REQUEST TO REINSTATE AN INTERIOR LOT LINE  
 13980 BLACK FOREST ROAD  
 LOT 7, BLOCK 1, APACHE WOODS SUBDIVISION  
 EL PASO COUNTY, COLORADO

0' 50' 100'  
 SCALE: 1" = 50'  
 JOB NO. 39043  
 OCTOBER 26, 2018

0' 50' 100'
 SCALE: 1" = 50'
 JOB NO. 39043
 DECEMBER 19, 2018

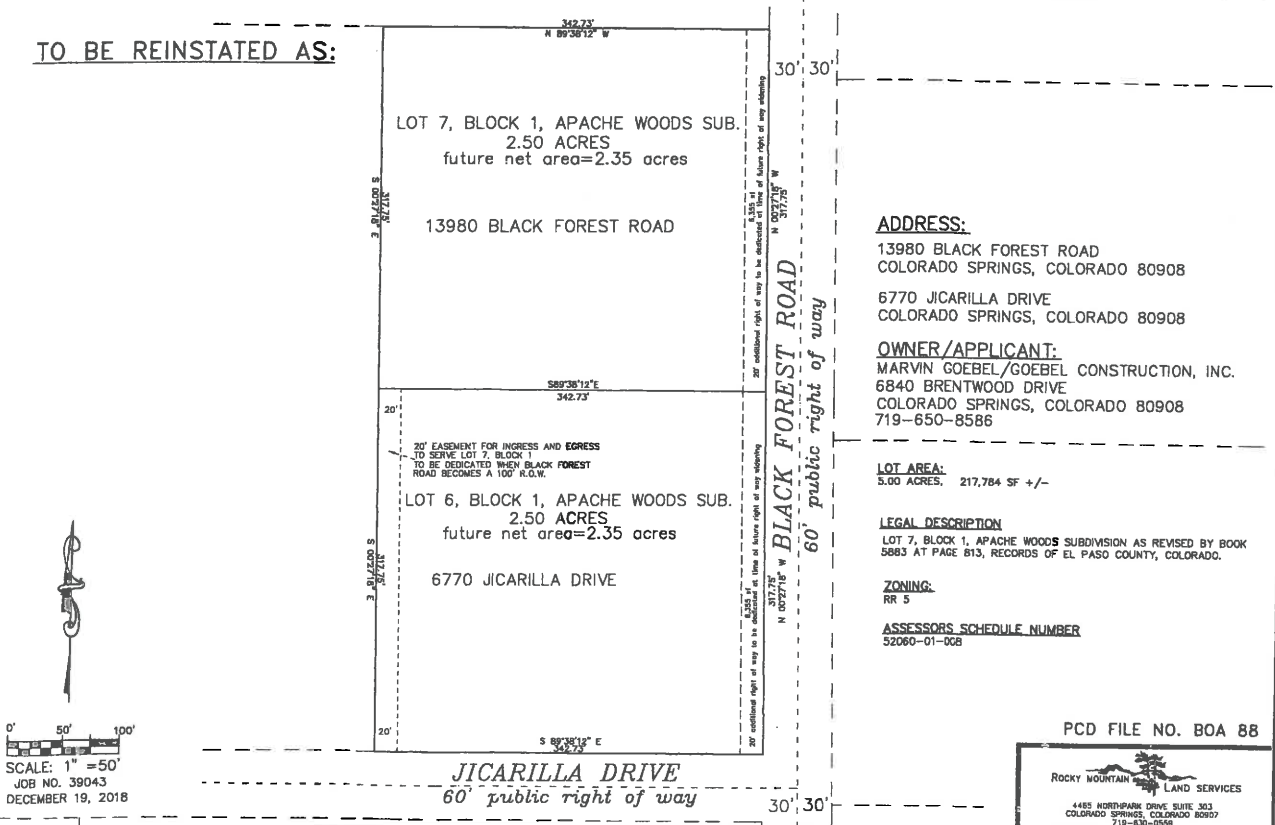
Show the ROW dedication for Black Forest Road. The dedication will affect parcel sizes.

Add PCD File No. BOA188

Show all adjacent property owners (address, owner, parcel ID)

You will need to address lot size in regards to potential loss of land to Right of Way in the letter of intent and site plan.
